COLORADO

Department of Transportation

July 8, 2020

RE: A Storage Place - Mini Warehouse - PPR1929

EROSION
CONTROL
PLAN
5/7

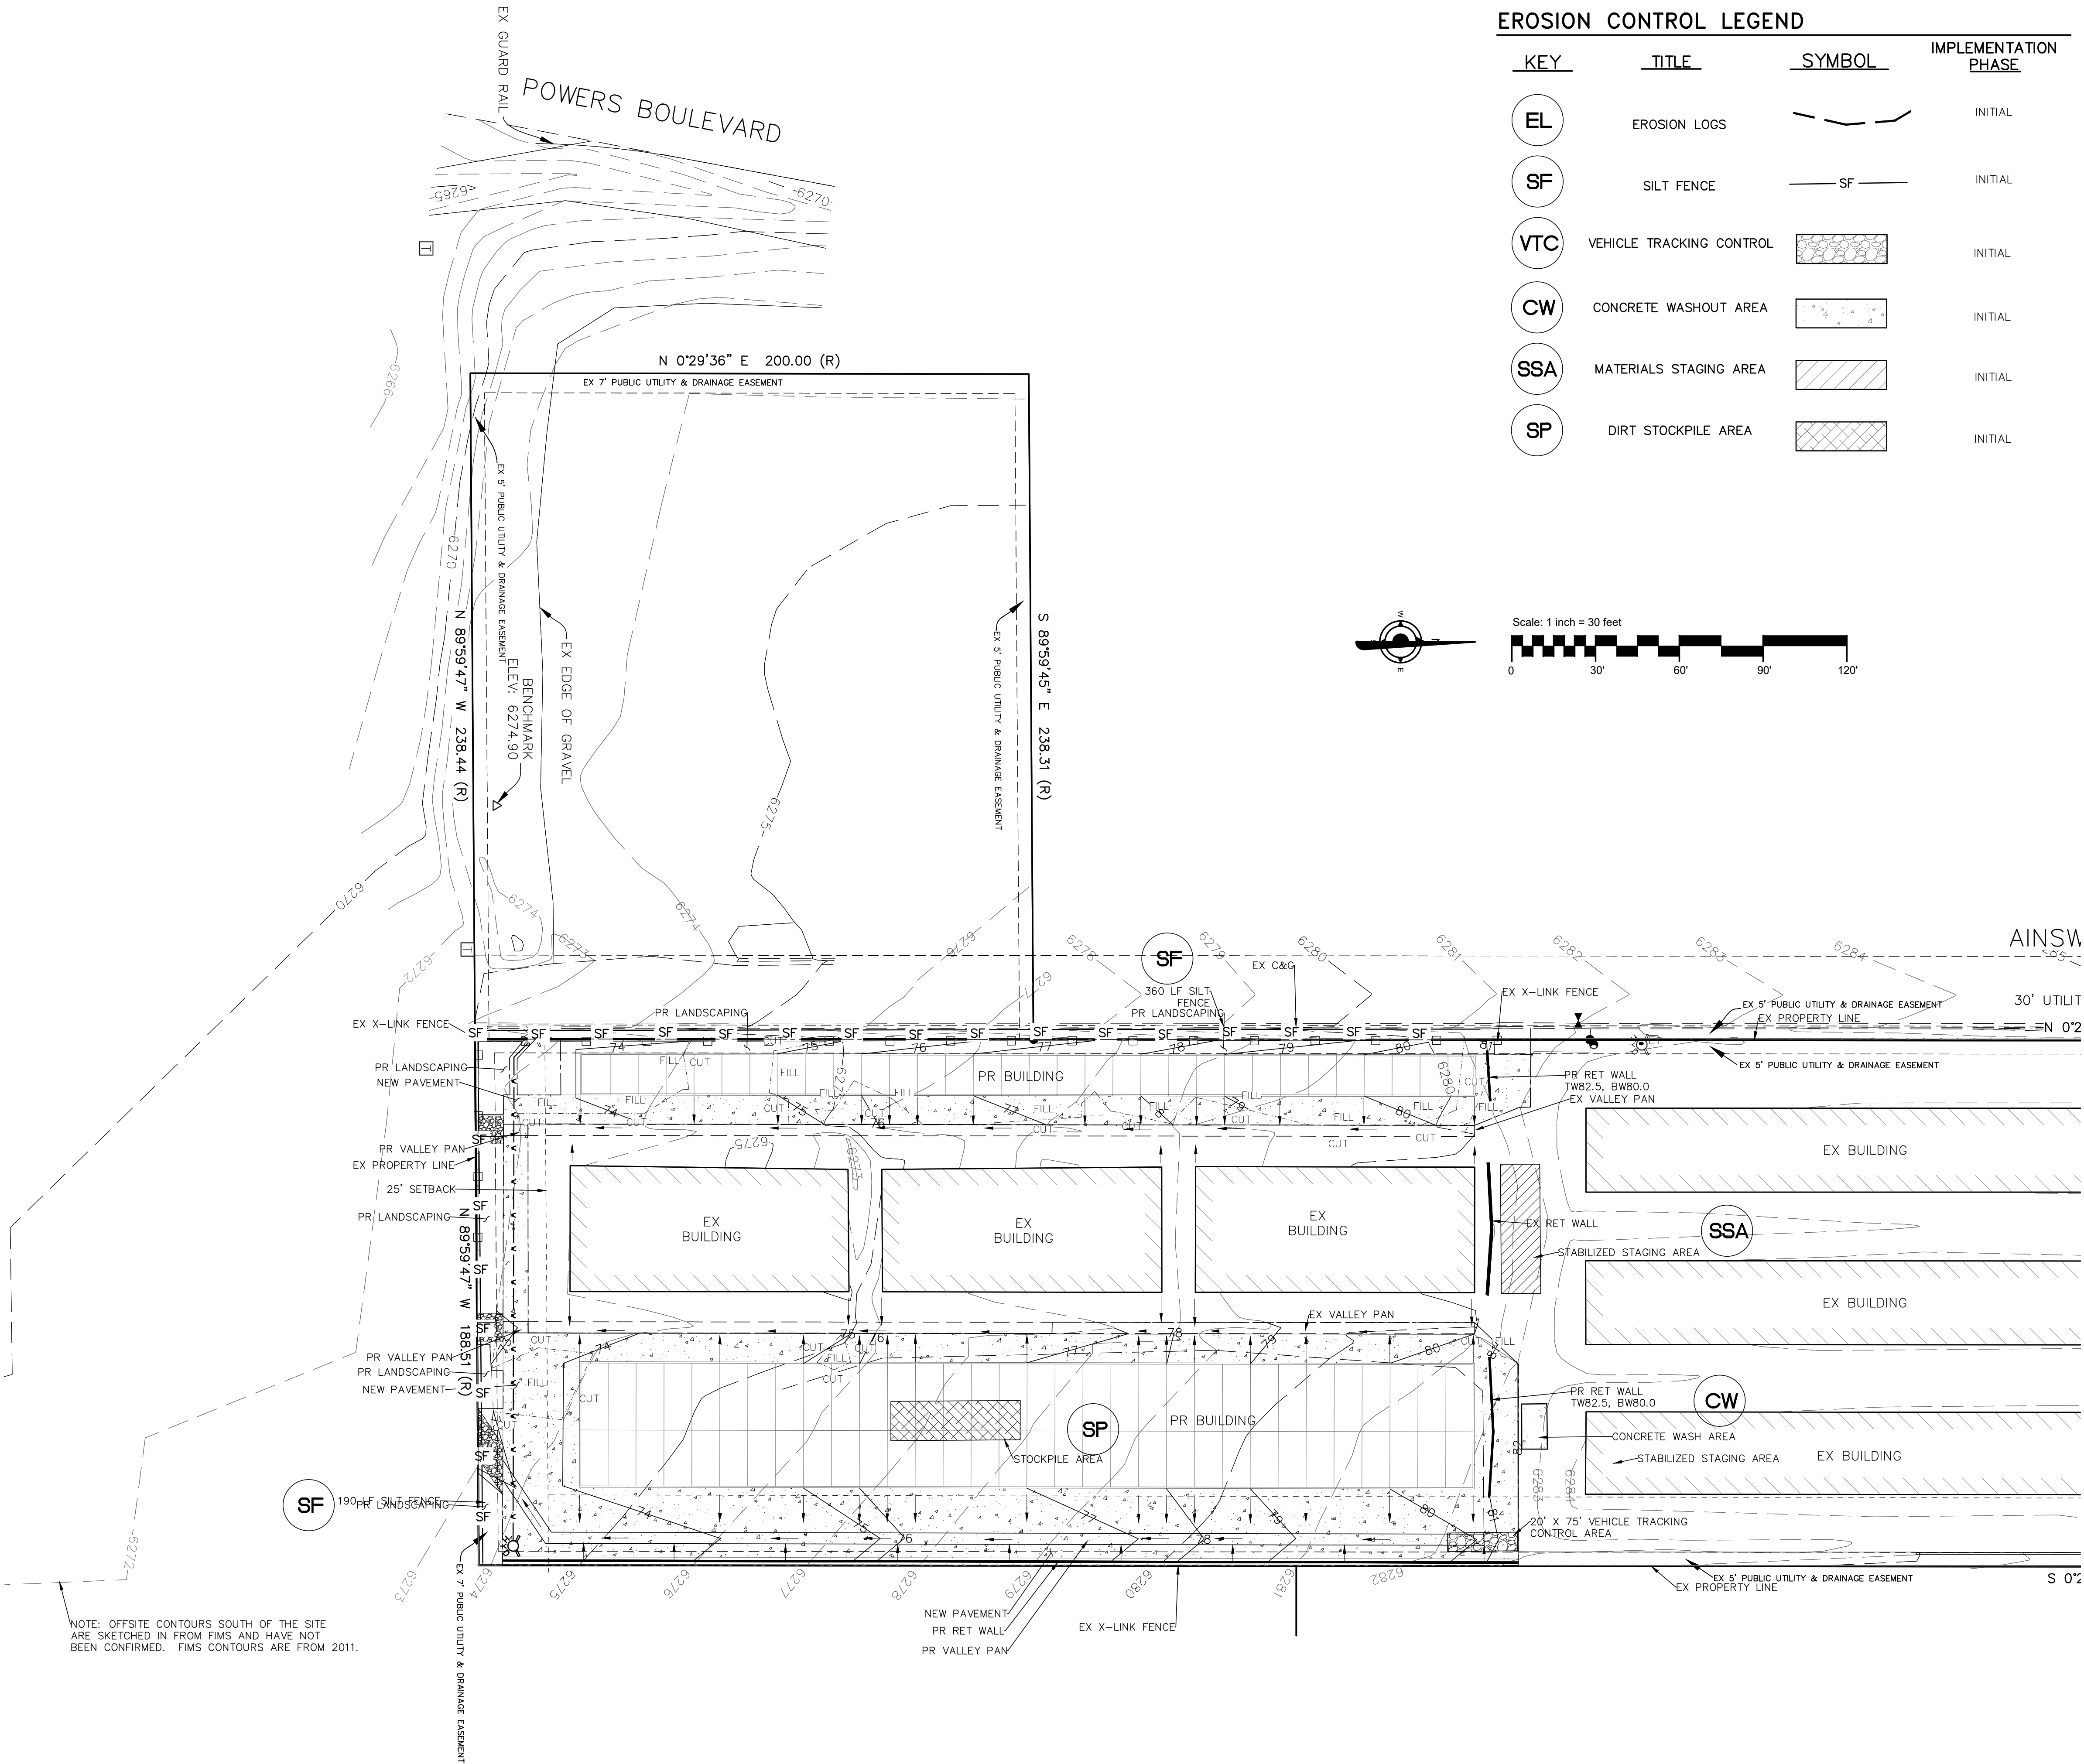
5. The width/edge of the 3 riprap pads that are located at the southern end of the site should be a minimum of 3 feet wider on each side of the concrete swale edges. I did not see the detail of the concrete swales that convey runoff to the 3 riprap pads so I cannot determine if the width of the proposed riprap pads is adequate?
6. Change the riprap pad thickness from 6" to 18".
